**Re: Chase Bank – Indian School Road  
6670 Indian School Road NE  
Traffic Circulation Layout  
Architect's Stamp 07-07-2021 (J18-D001C)**

Based upon the information provided in your submittal received 07-07-2021, the above referenced plan cannot be approved for Building Permit until the following comments are addressed:

TRAFFIC CIRCULATION PLAN

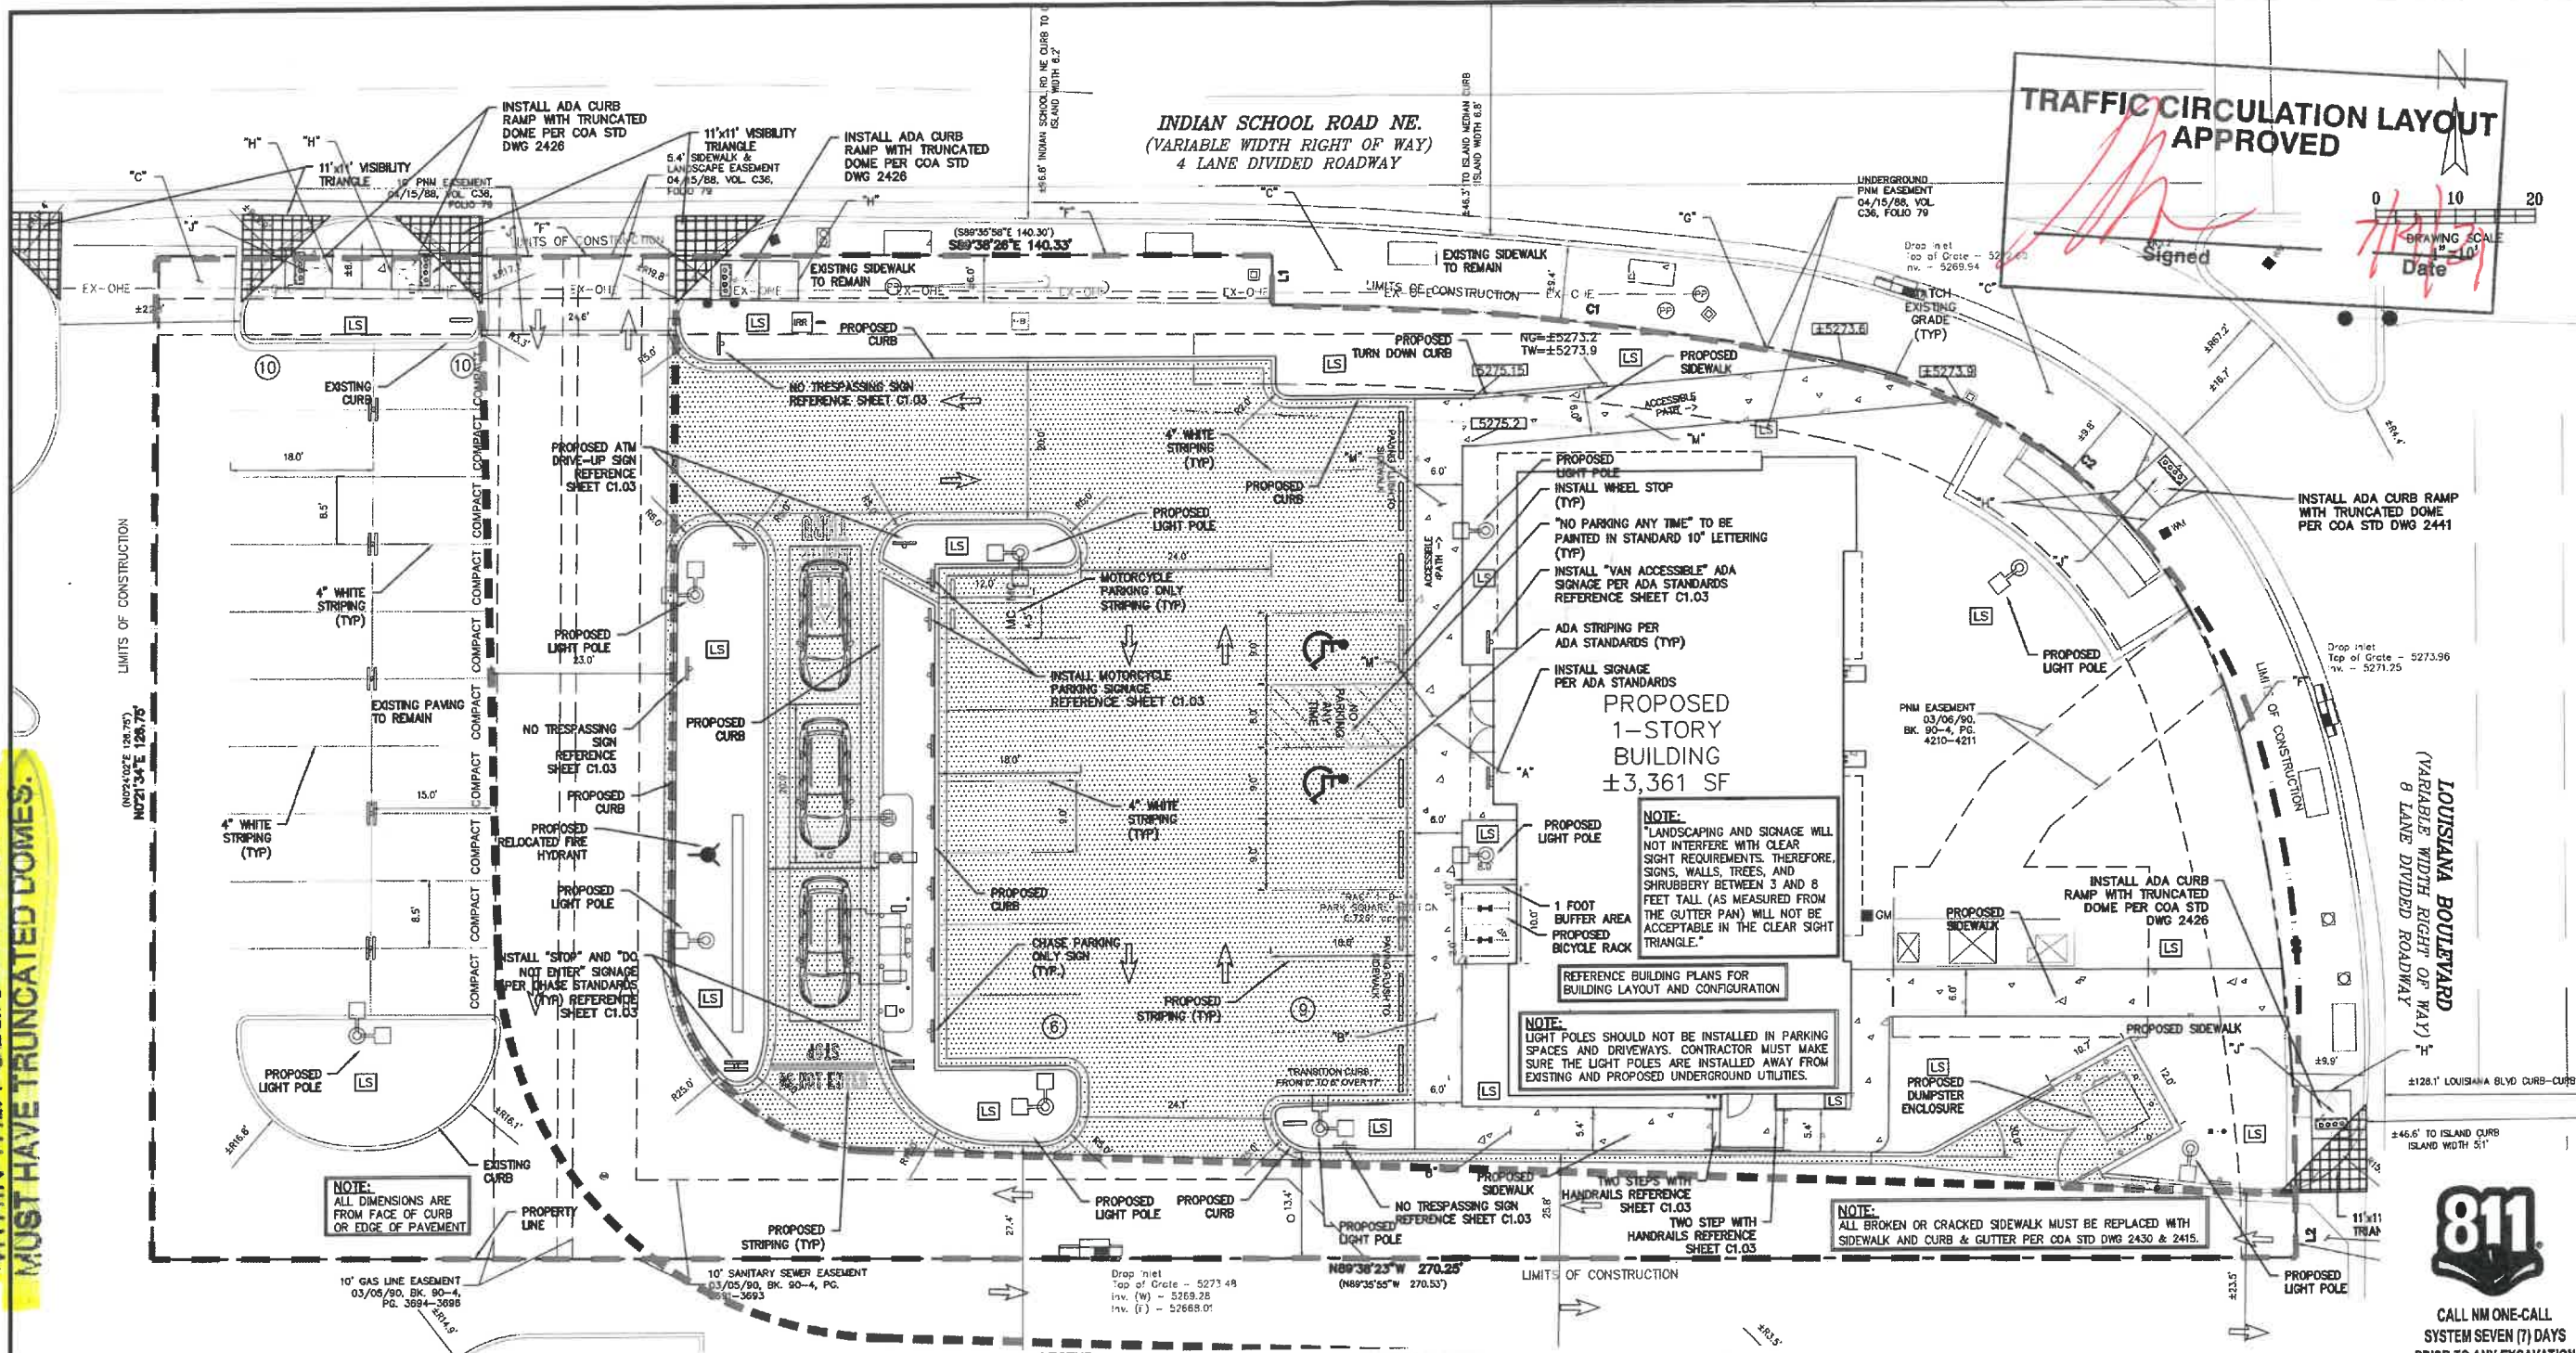
2. The new location of the Solid Waste enclosure appears to impact 3 parking stalls that have been removed. Please provide a new parking stall calculation to substantiate the loss of the stall wouldn't impact the total required stall and/or provide a statement as to this concern.

**Response: Under existing condition the leased are encompasses 32 parking spaces. Under proposed conditions, the amount of parking spaces increased to a total of 35 spaces. There is a net increase of 3 parking spaces from existing conditions, providing additional onsite parking. Explain how are you going to accommodate the extra 3 parking stalls on site plan/ Identify on site plan.**

3. Add a note stating "All broken or cracked sidewalk must be replaced with sidewalk and curb & gutter." A build note must be provided referring to the appropriate City Standard drawing.

**Response: Note added. Reference lower area near the dumpster enclosure.**

**Add COA std dwg 2430 & 2415 to the note.**

4. Please provide a letter of response for all comments given.
5. Construction Note B; Does this note need to be their? Since your have provided the 6 ft width requirements for ADA pathway from public sidewalk and ADA parking aisle to building entrance.
